re. **Town & Country Planning Act 1990**
Application ref: P/47/11
52 East Front Road, Pagham
Proposed extension to existing dwelling

I refer to the above Detail Planning application, which I have viewed on the District Council's website and as owner of adjoining land, would make the following comments:

EAST ELEVATION

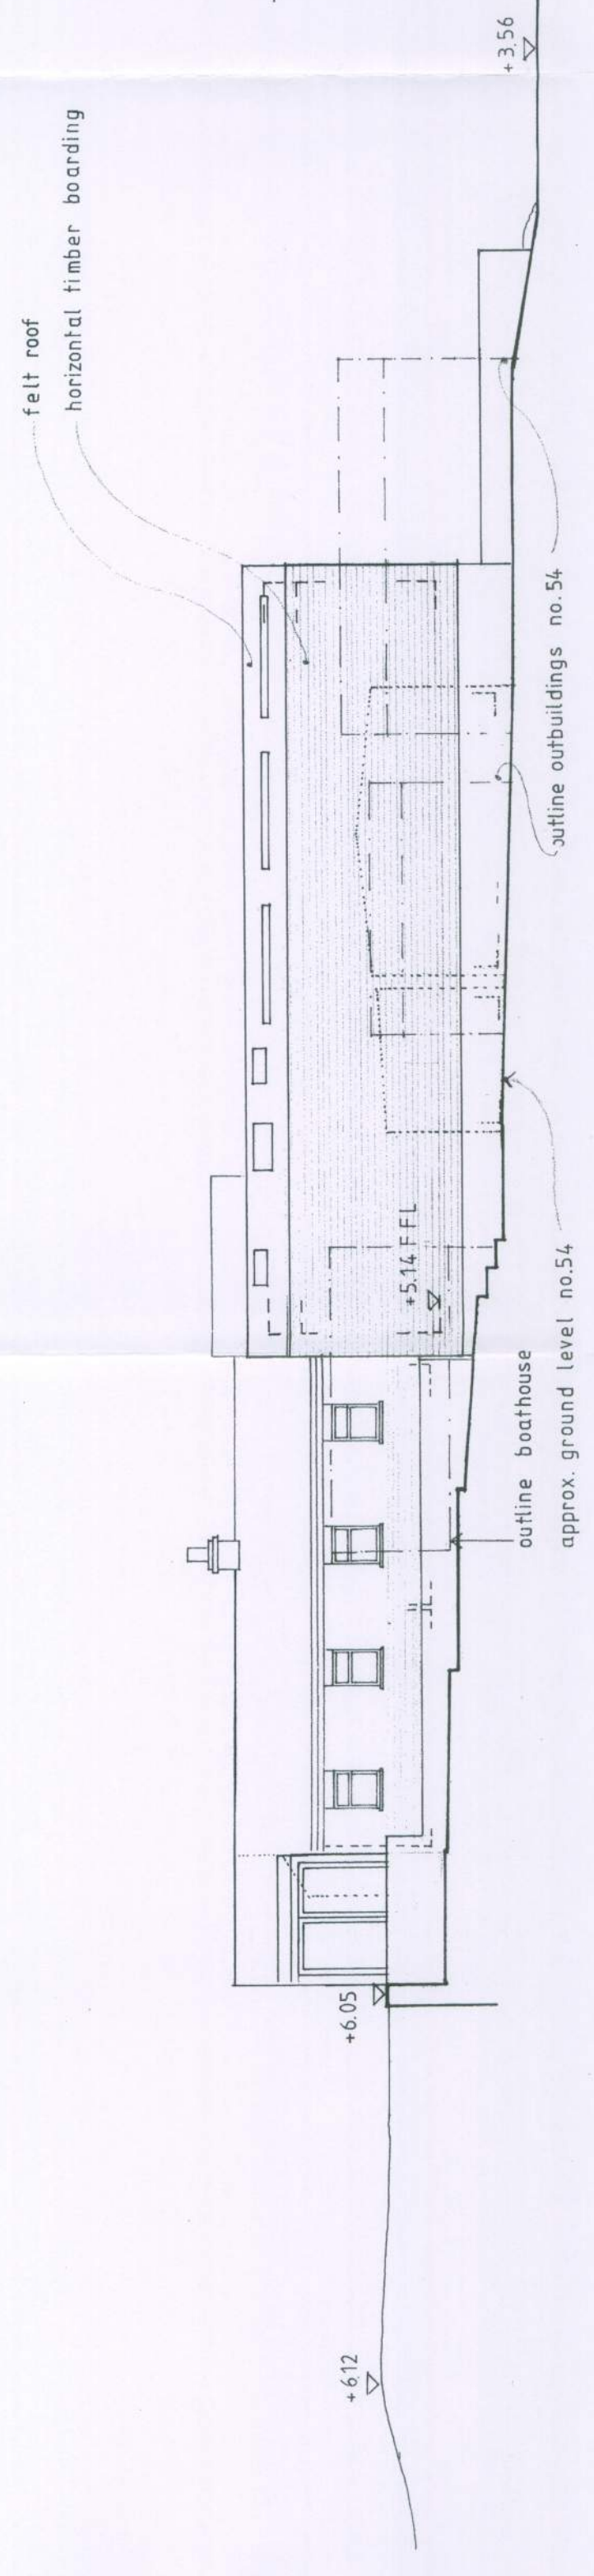
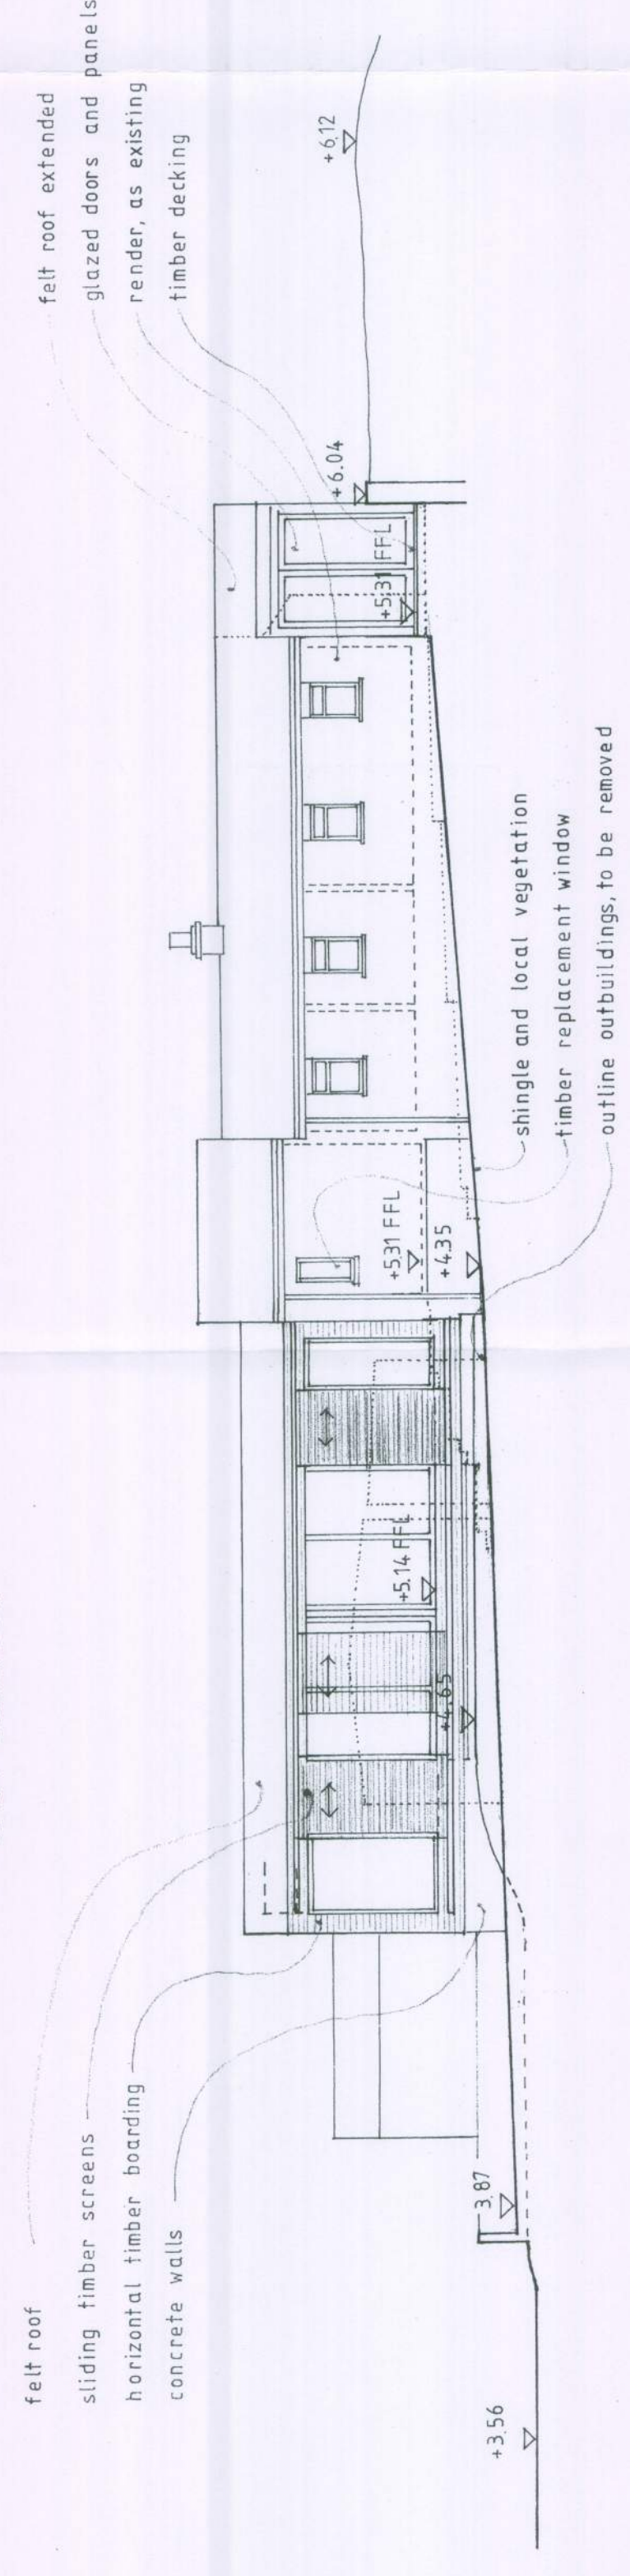
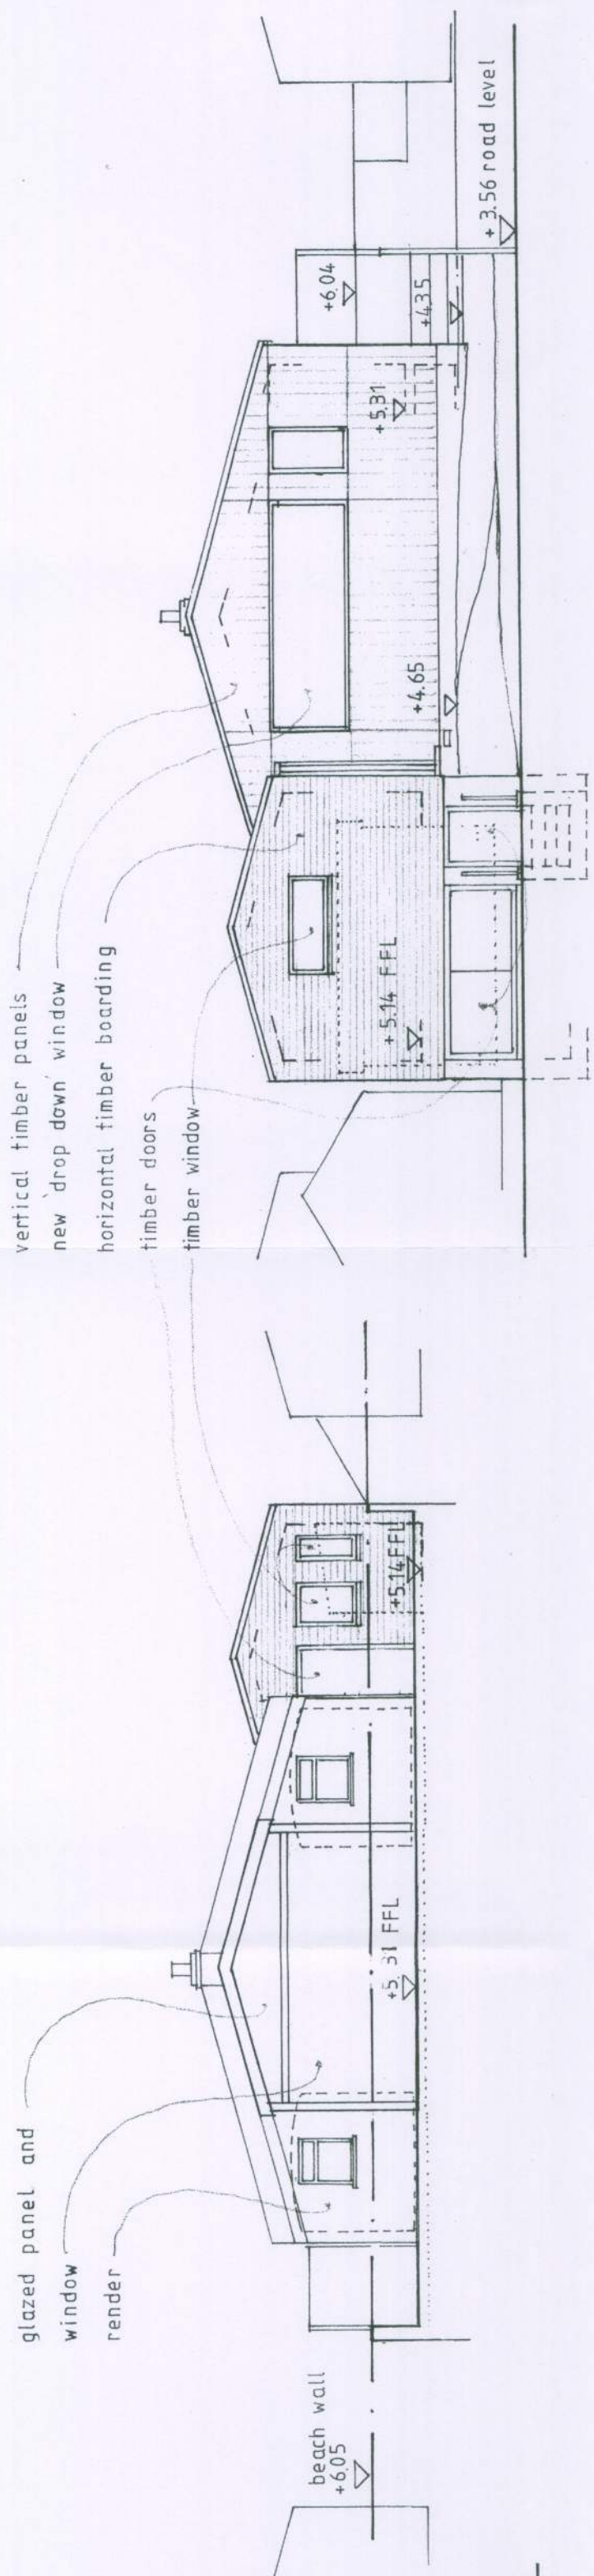
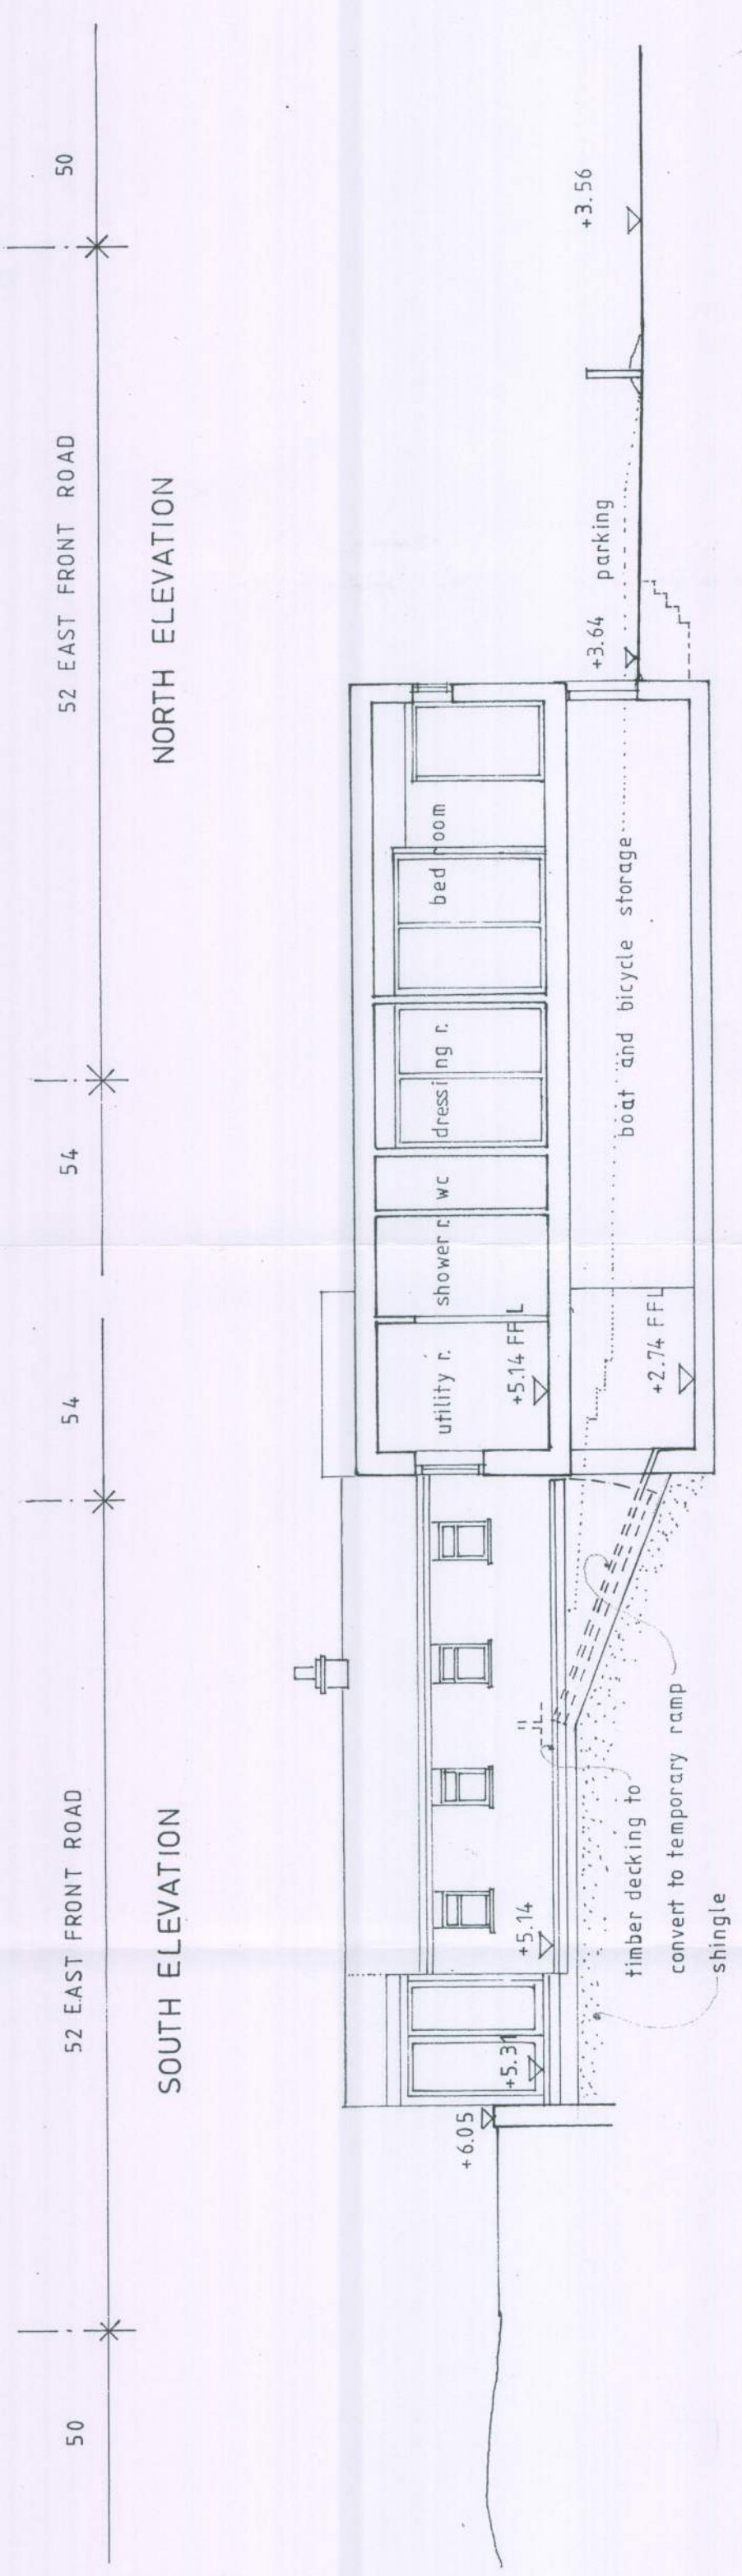
The new building shows a substantial and overbearing bulk within the street scene and should be reduced in size and scale. The bulk of this proposed development, if Approved, will create an unwelcome precedent. It is considered that the present proposal represents a gross over-development of the site and the scheme should be reduced.

It should also be noted that the scheme proposes the installation of rooflights within the roof construction, which again is contrary to Local Plan Policies for the Beach Estate, and if allowed will create a precedent, which will undermine the Planning Authority's policies.

The proposal to position substantial "drop-down" windows directly onto the foreshore would also seem to be impractical in such an exposed location.

The appearance of the building is also completely inappropriate within this Area of Special Character and if allowed will create an extremely unwelcome precedent. As mentioned above, the proposal is contrary to Policy GEN7 and Area 1 of the Arun District Local Plan.

SECTION A-A

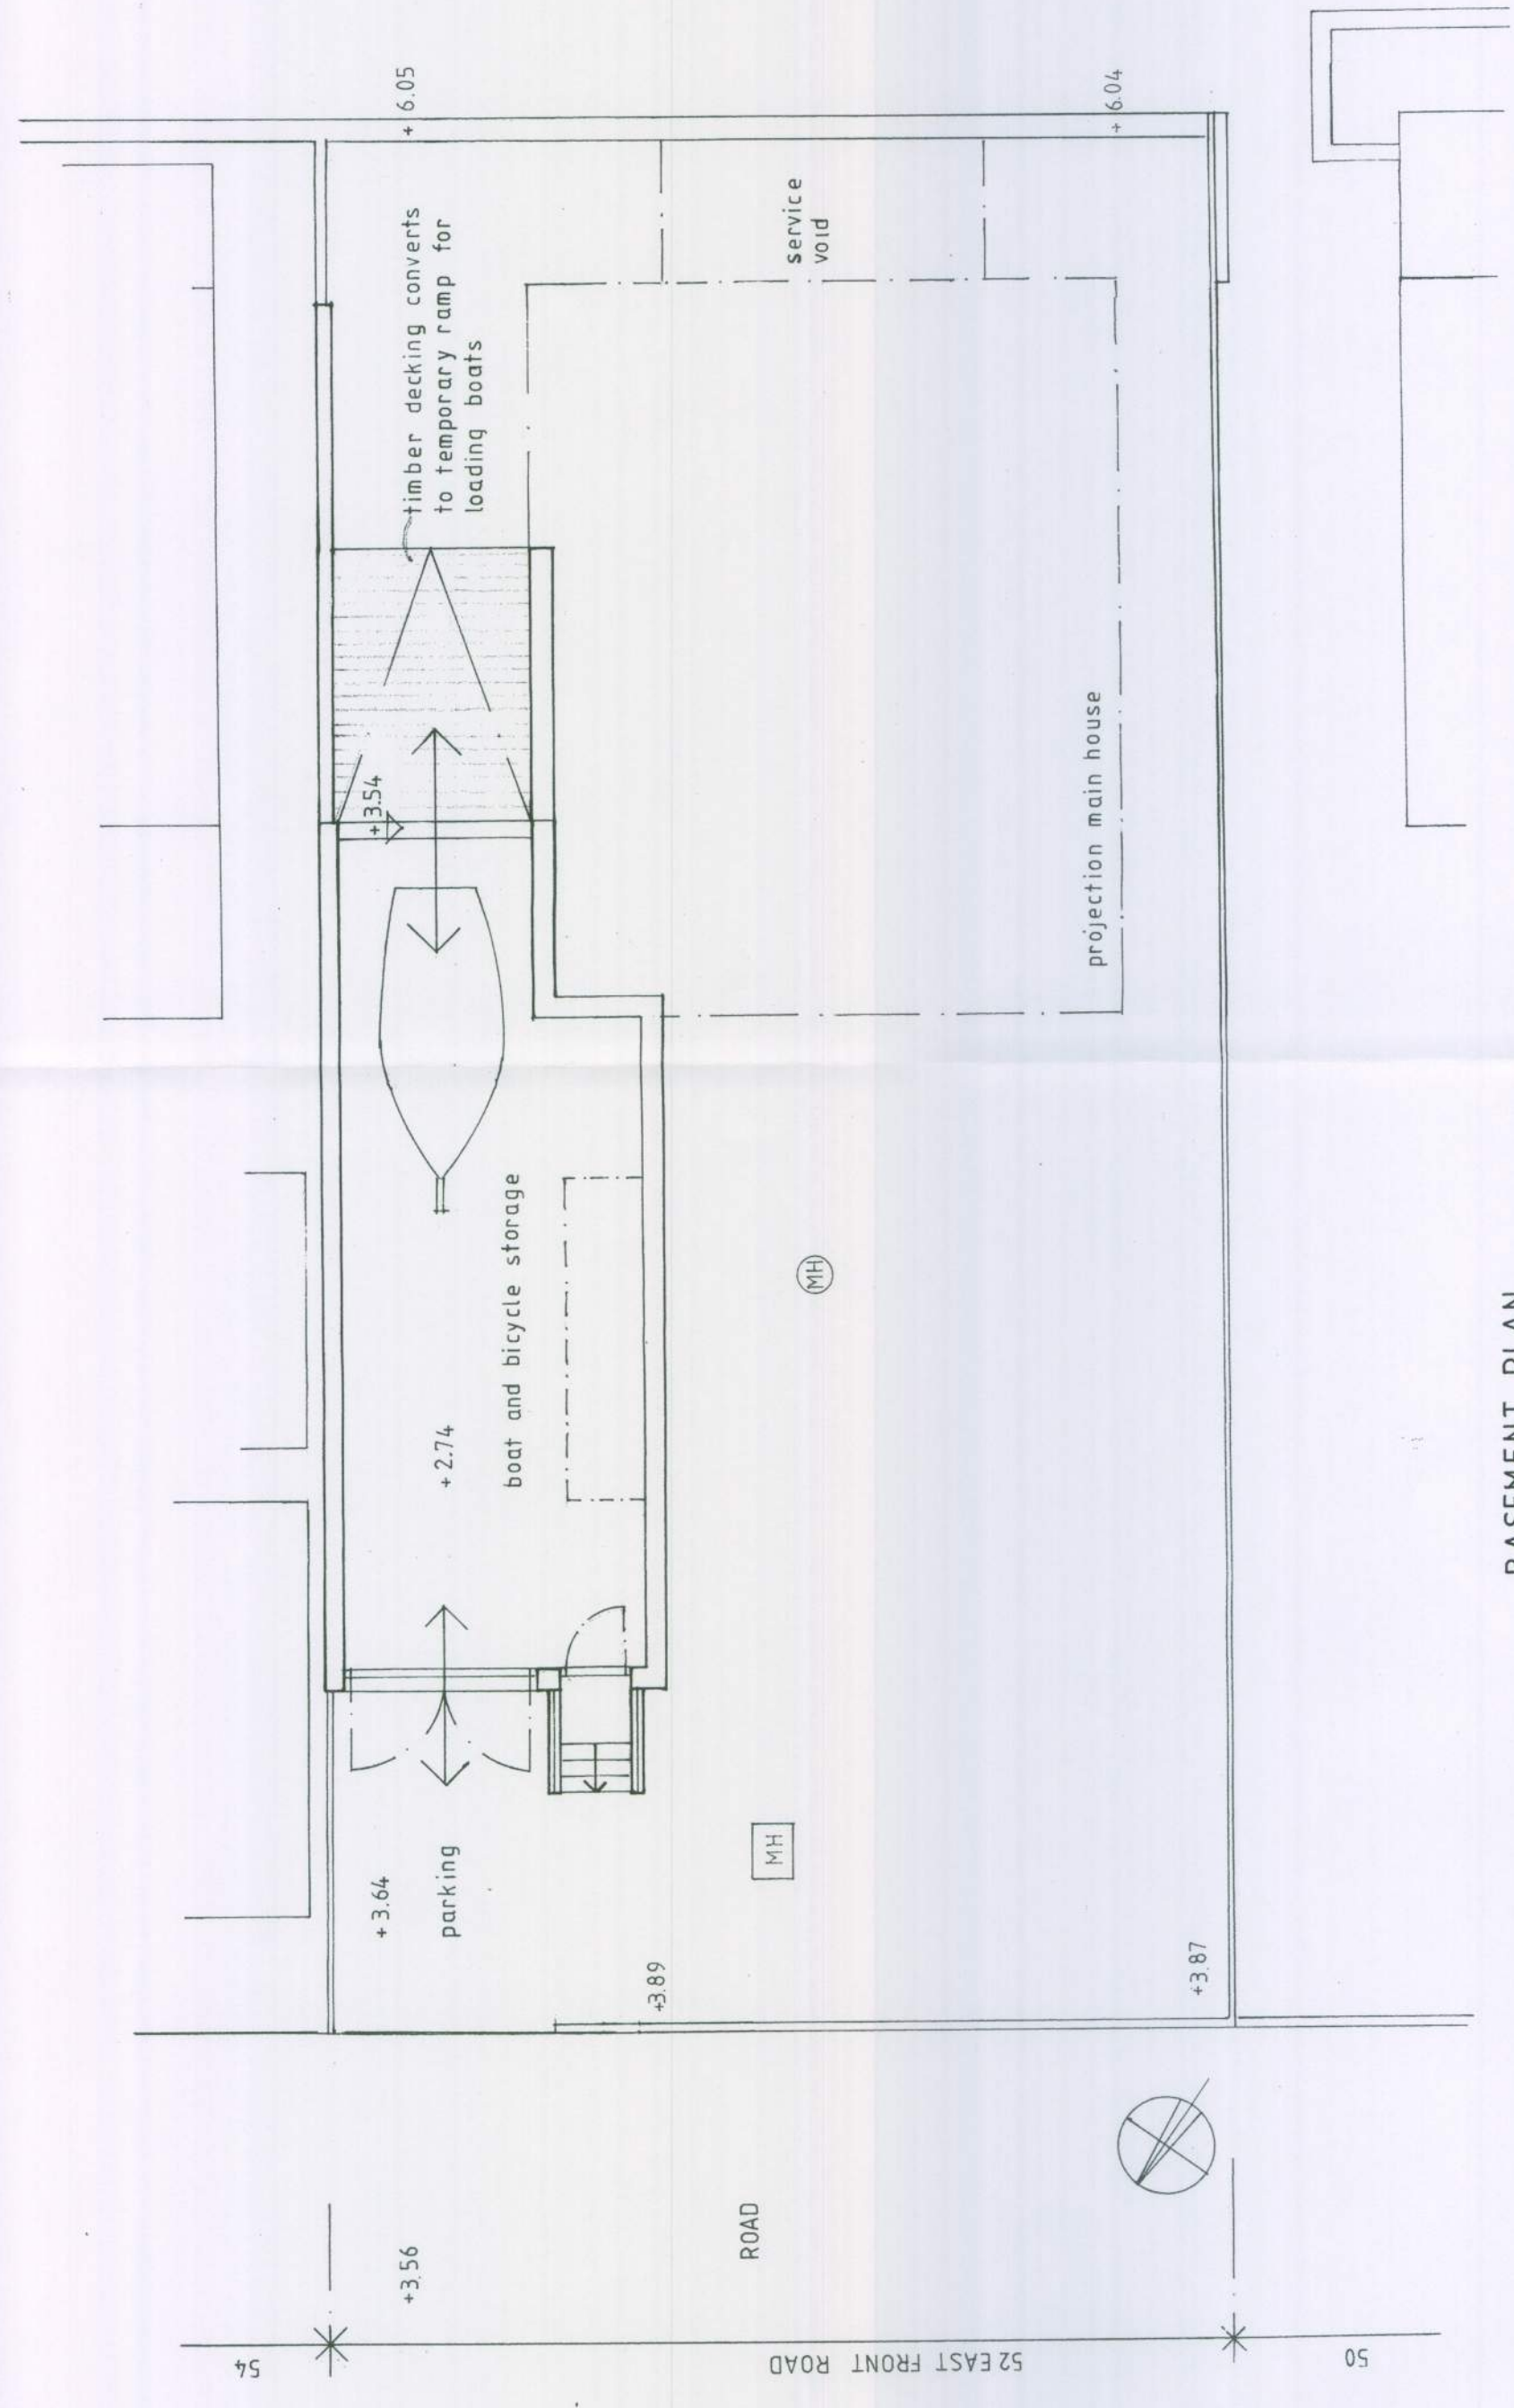
The proposed extension to the north of the original building is a two-storey structure of basement and elevated ground floor accommodation, which as mentioned above proposes a structure of considerable bulk which it is hoped the Planning Authority would consider unacceptable within the street scene. The two-storey construction is also contrary to Local Plan Policies for the Beach Estate, and if Approved will create an unwelcome precedent.

The formation of a basement with a finished floor level as defined, proposed at 2.74 OAD is over 3.000 (10'0") below existing levels on the adjoining beach foreshore. This is completely inappropriate in this location and in the opinion of the Directors is verging on downright dangerous.

In order to achieve the construction at this depth, excavations to a depth of 12-14'0" below beach level must be created, which in the shingle sub-strata will cause considerable local disturbance. The adjoining site to the east must be protected and maintained stable and as a consequence a substantial retaining wall would need to be constructed on the boundary. These extensive civil works will be extremely destructive adjacent to a shingle foreshore already threatened by erosion from wave action must surely be considered unwise and inappropriate.

The arrangement of the basement boathouse with a ramp down from the foreshore will definitely result in basement flooding with any over-topping event on high tide and/or storm conditions. This arrangement must surely be considered a completely unsuitable proposal which could endanger adjoining properties.
